From: Mark Warwick <Mark.Warwick@arun.gov.uk>
Sent: 22 October 2019 14:47
To: James Elsey [REDACTED]
Cc: Andrew Wood <Andrew.Wood@arun.gov.uk>
Subject: Merry England Nursery, Dappers Lane, Angmering

I write further to our pre-commencement site meeting (Condition 17, A/142/16/OUT) and simultaneous review of A/132/19/DOC on 11th October 2019.

| Draft Tree Protection Plan |               |                     |

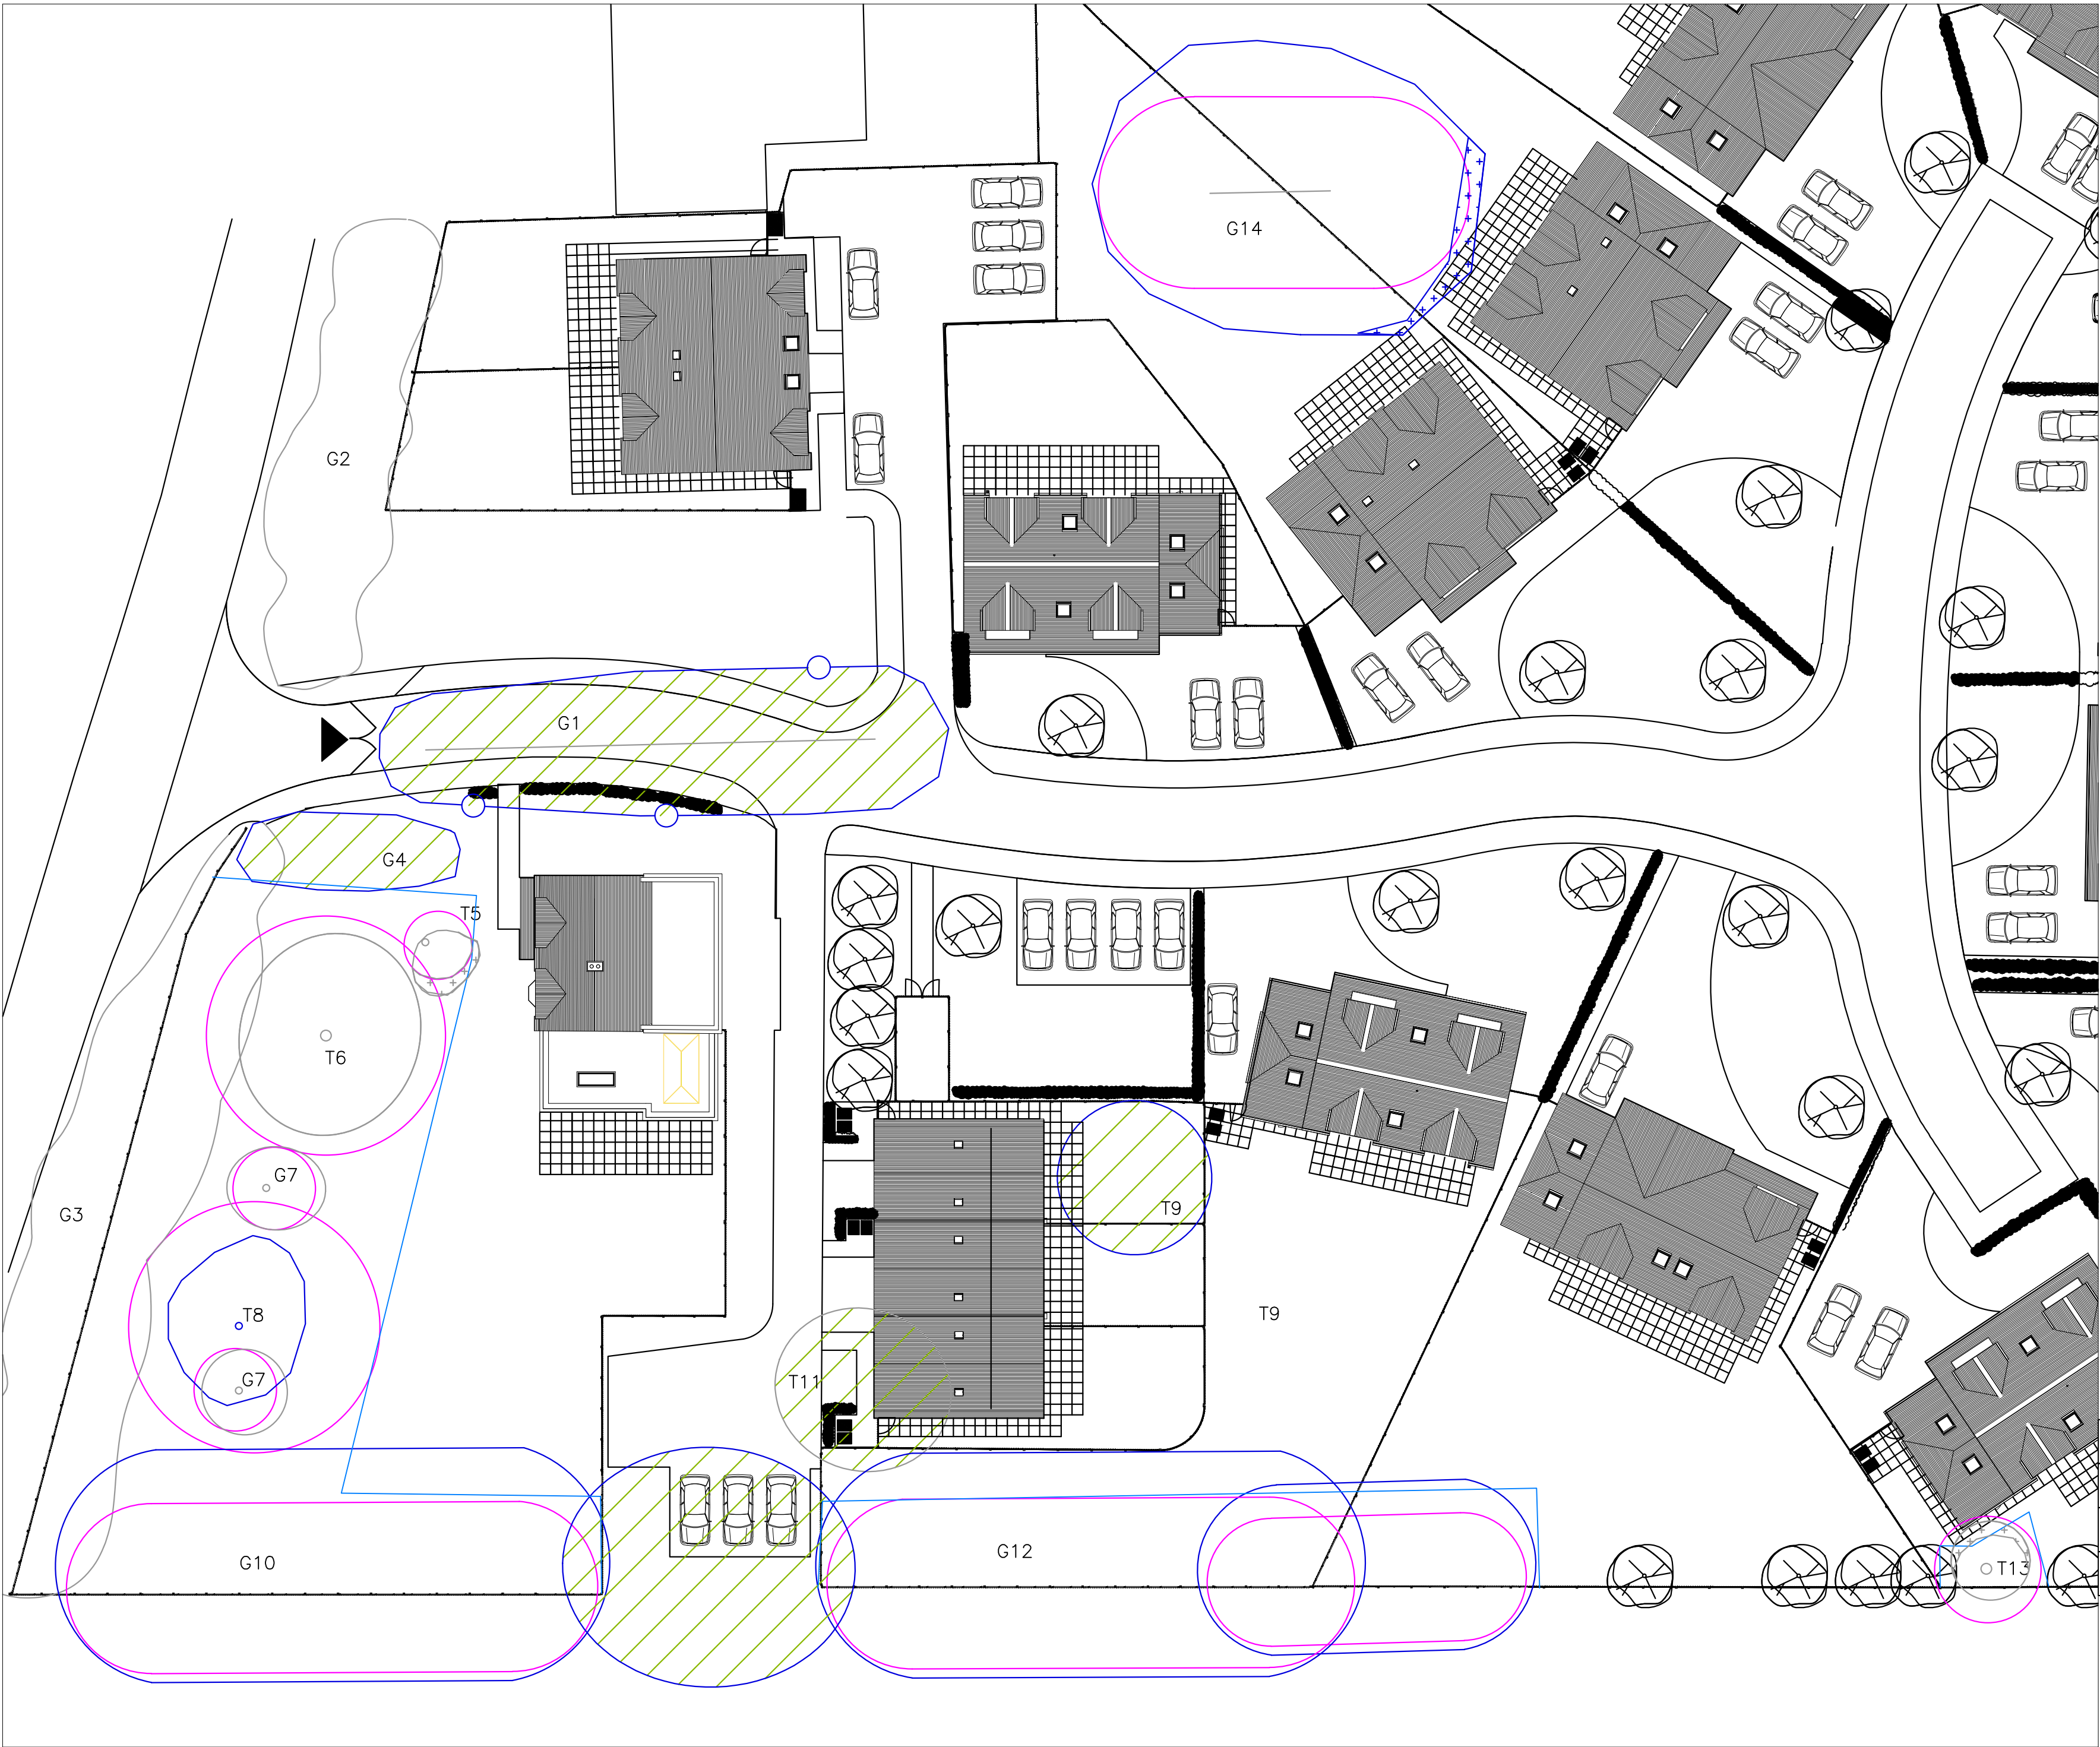
- Joanna/James – please submit details of your replacement tree planting scheme to mitigate the future loss of G1.
- Tree Protection Fencing is largely as shown on the approved plan with only a few minor refinements to be implemented, before that element of the DOC application can be recommended for discharge. Joanna – as discussed, please forward evidence of those refinements in due course (and amended plan).
